Section 75W Amendment to MP10_0016 - Scottish Hospital Paddington

This letter constitutes a request to amend the Project Approval for MP10_0016 (Scottish Hospital Paddington).

**Re: Presbyterian Aged Care, Paddington
Planning Assessment Condition E17
Overhead Electrical / Telecommunication Services to be Located Underground**

ELECTRICAL SERVICES
EXTERNAL SITE PLAN

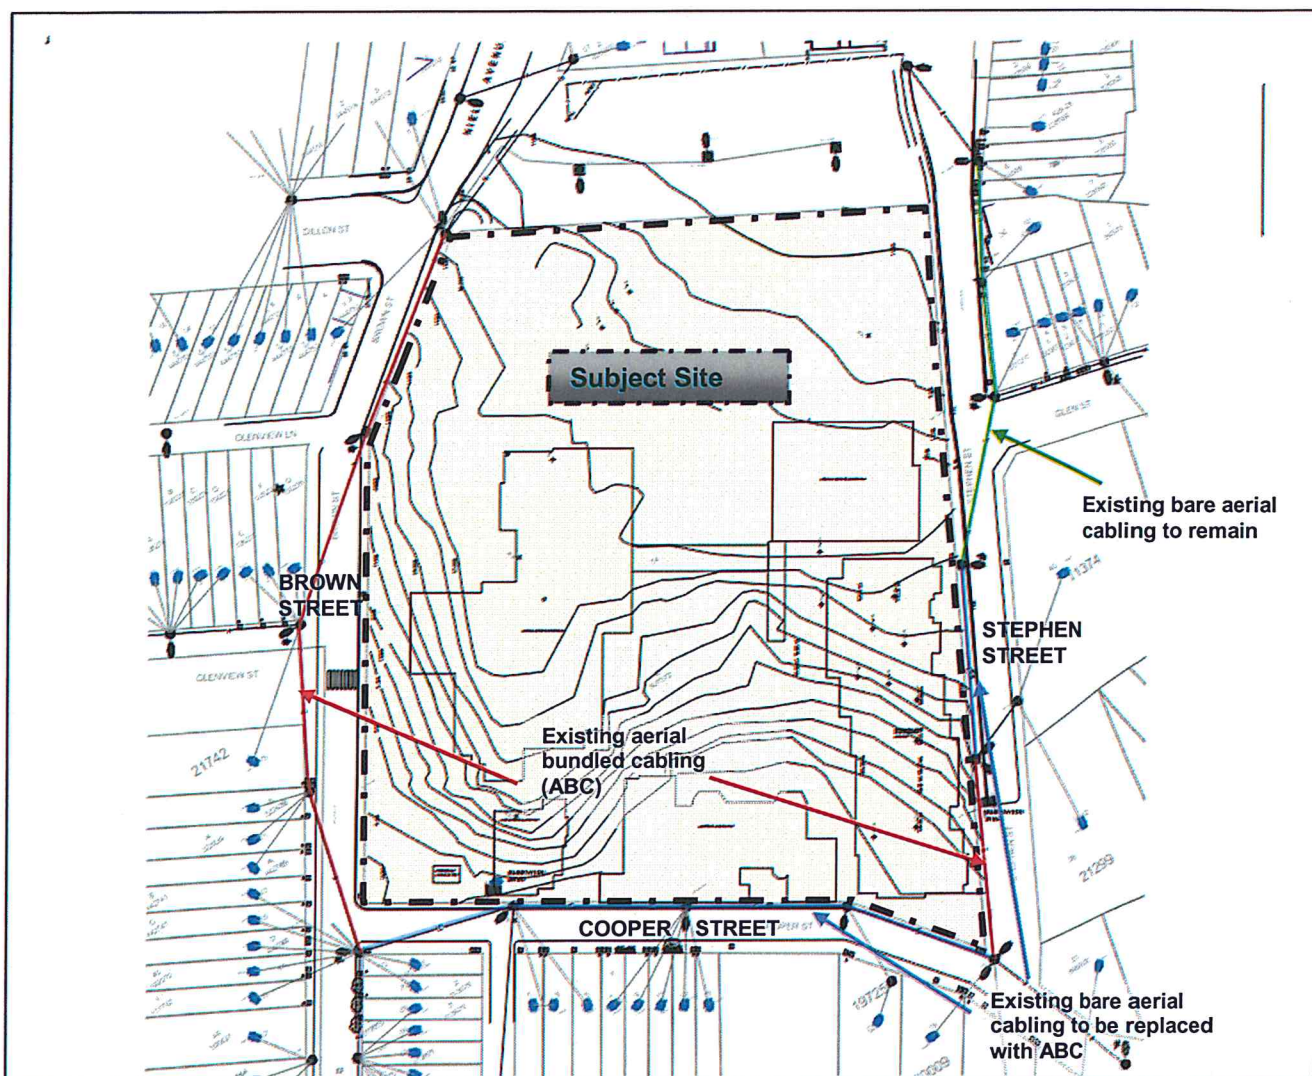
- Altering overhead bare aerial to bundled aerial cabling has already taken place throughout the Paddington area. This aerial cabling alteration is evident along Brown St and Stephen St. The extent of the existing overhead bare cabling with respect to the overhead bundled cabling is illustrated on the attached site plan drawing Figure 1.

As a more favourable alternative, EMF Griffiths are recommending that the existing bare aerial cabling is replaced with aerial bundled cabling. This is a much more discrete, unobtrusive and visually appealing outcome where the four existing bare cables are replaced with a single bundled cable. This is consistent with Ausgrid network upgrade works that have already taken place in the vicinity, as indicated in Figure 1.

The proponent shall meet the full cost of bundling the overhead power lines located along the Brown Street, Cooper Street and Stephen Street frontages of the development site (where works of this nature have not already been undertaken). The Proponent shall liaise directly with the relevant service utility authorities to organise for the wires/cables to be bundled. All wires/cables must be bundled to the satisfaction of the relevant service utility authority prior to the issuing of an Occupation Certificate for the development.
